**From:** Bianca Thornton  
**Sent:** Thursday, 22 August 2019 3:03 PM  
**To:** kelly.gee@suez.com  
**Subject:** Request for Information - Spring Farm ARRT Facility MOD 6  
**Attachments:** Consolidated comments on RTS.pdf

I refer to the Response to Submissions (RTS) report for the Modification Application to the Spring Farm ARRT Facility (005\_0098 MOD 6). The RTS was referred to Camden Council, the EPA and ESS (formerly OEH) to confirm that the issues raised in their submissions have been addressed. Their responses are attached.

Figure 6: Weighbridge Truck Event Measured at East Village

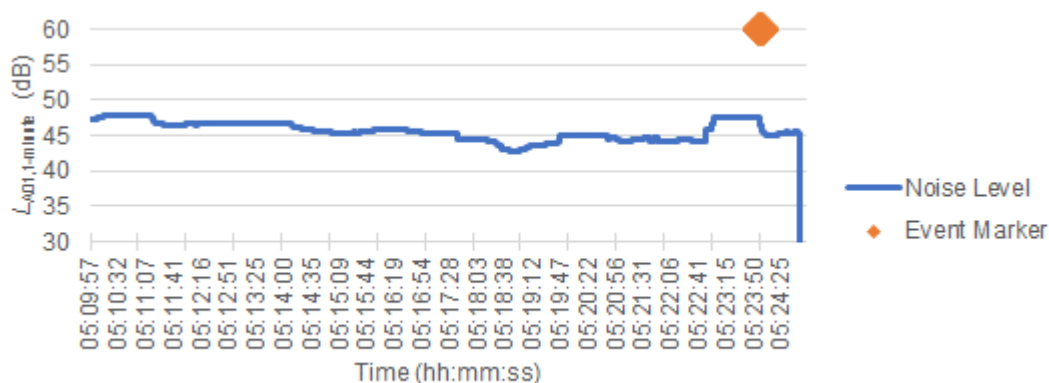
- RTS for MOD 6: Lot 35 DP 1098588.
- Noise:** Given the proximity to sensitive receivers, the NIA should include an assessment of the noise impacts between 6 am and 7 am from vehicles accessing the site. This should include noise from the weighbridge area.

*Figure 2: Process flow diagram for Industrial Liquid Wastes*

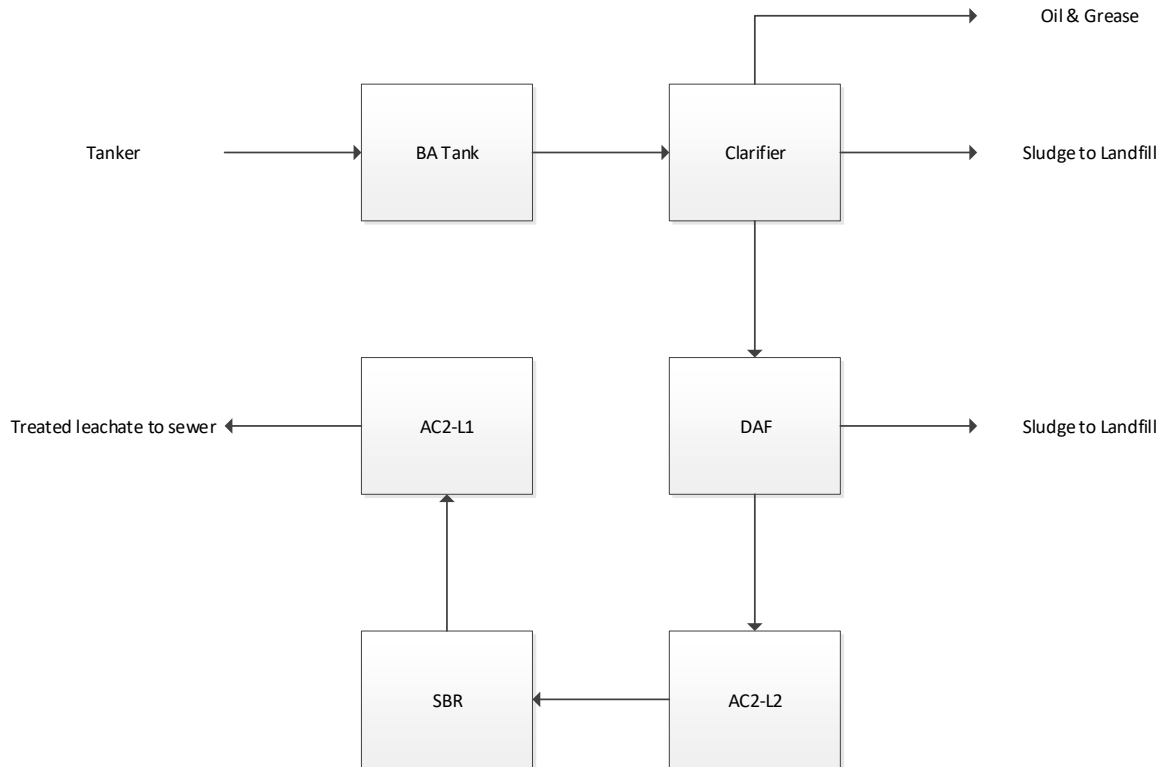
- Industrial liquid waste:** There appears to be some discrepancy on the processing of industrial liquid waste at the facility. The RTS states that industrial liquid waste was assessed and approved as part of MOD 5. The Department's Assessment Report for MOD 5 refers to organic liquid waste and leachate but not industrial liquid waste, inferring that the processing of liquid industrial waste was not assessed. This is reflected in the Instrument of Modification.
